From:
To: [DCAdmin](#)
Subject: Application Number 2020/94096
Date: 01 February 2022 10:39:06

Please take into consideration comments regarding proposed plans for further development by Jones Homes.

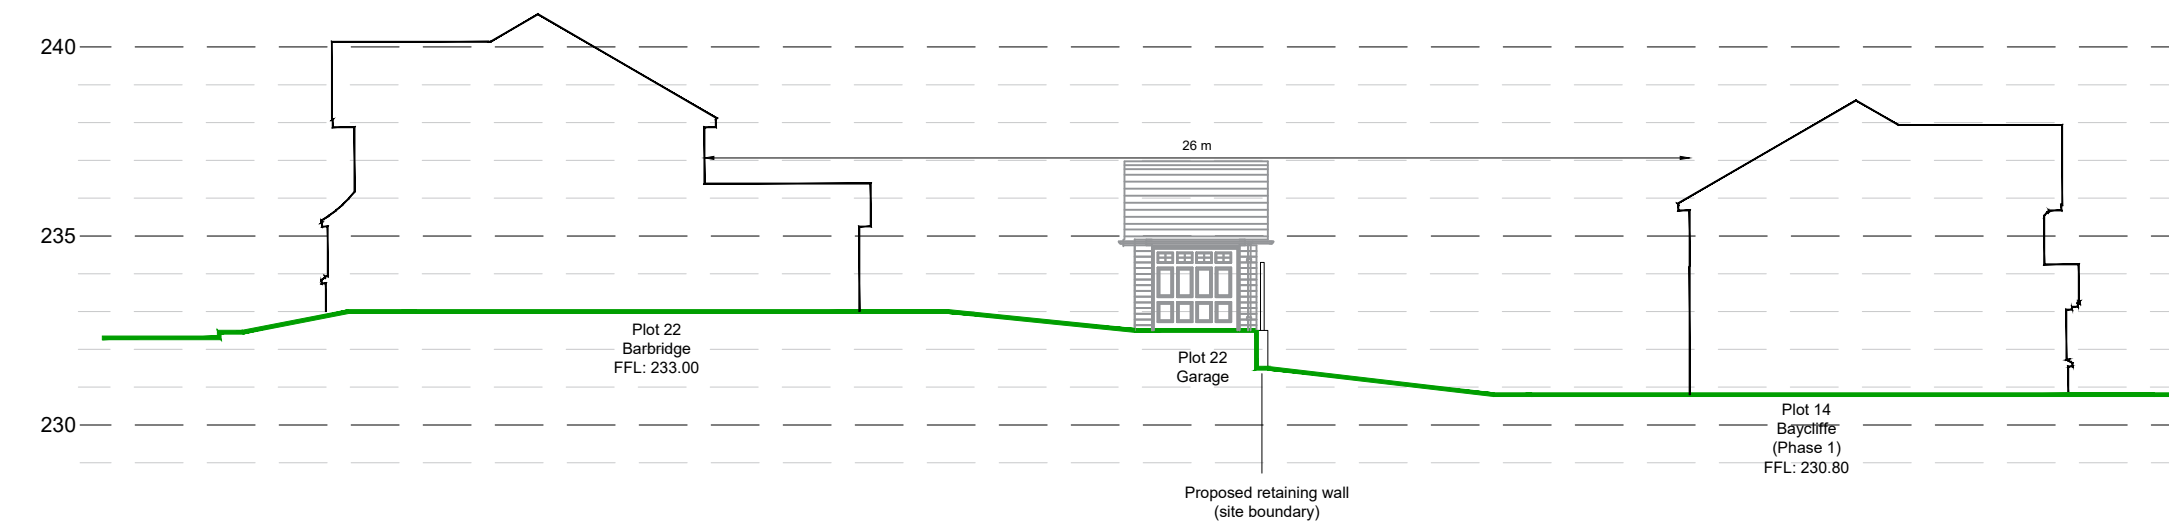
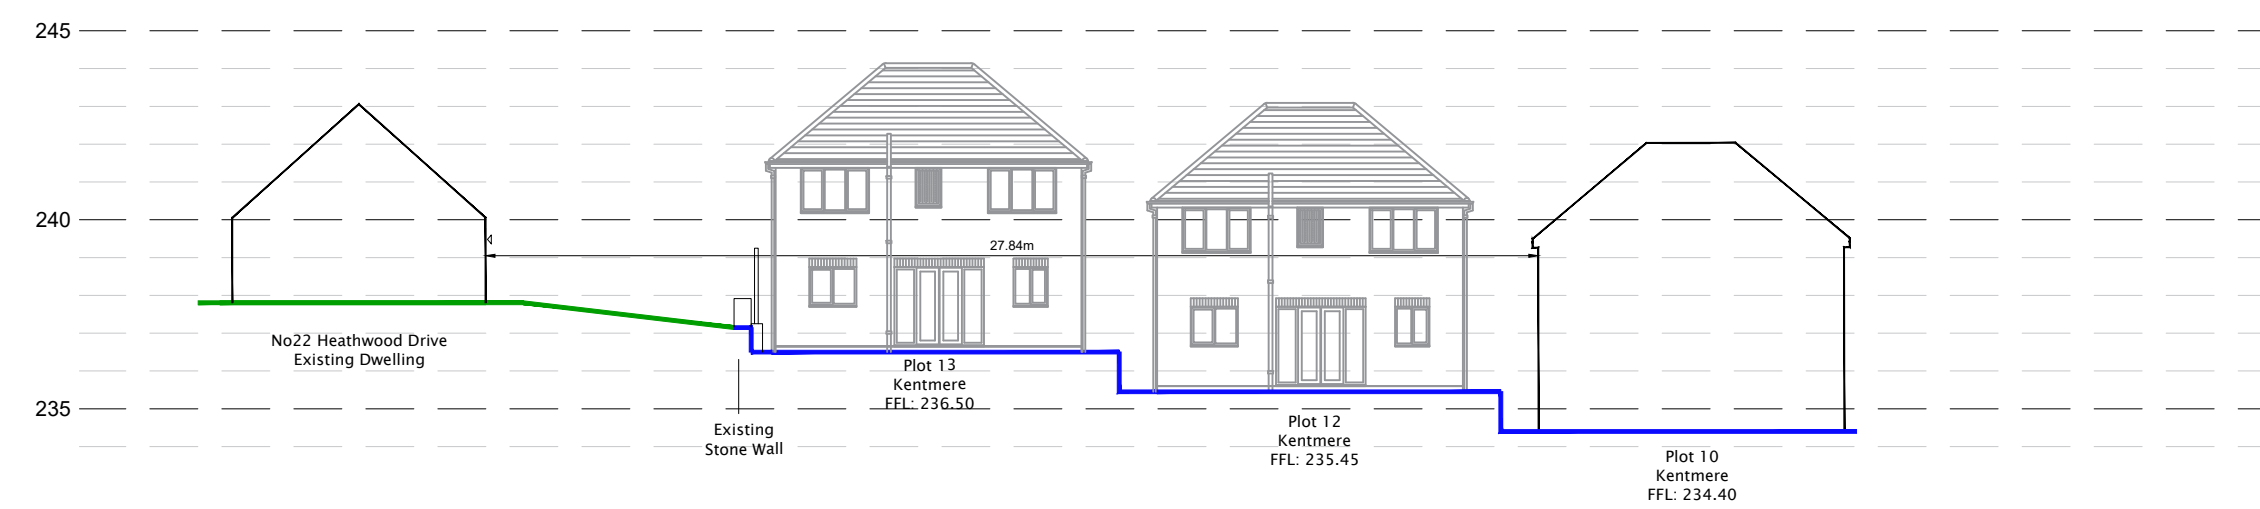
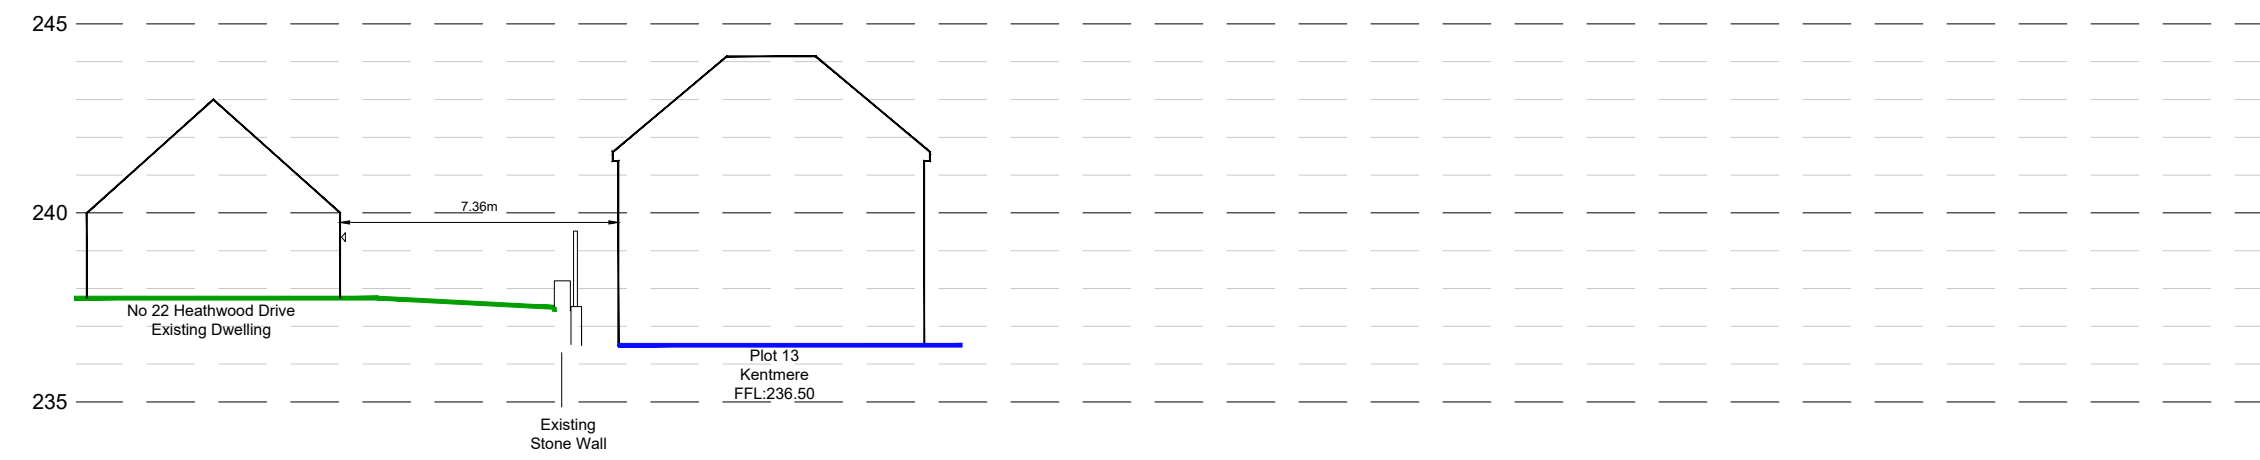
Our property will back on to proposed plot 22 from the proposed plans. Our garden has a raised area which Jones Homes put in when they built our property in 2020 this was due to land being so uneven when they came to do the garden, our raised area and border fence is 2ft higher than the rest of our garden.

The land behind where it is proposed a driveway and garage is going to be built will be substantially higher around 1.5-2m with the possibility to see over the fence into our garden/kitchen/dining area affecting the privacy of our garden and rear of our property.

We are requesting that the elevation of the plots backing on to the house which are currently in situ from the first development is reconsidered. This would significantly reduce the issue of privacy and feeling overlooked. If the house style of plot would be changed to a house for example a Kentmere, that has an integrated garage and driveway at the front of the house instead on the boundary of our garden this would also reduce the issue of privacy.
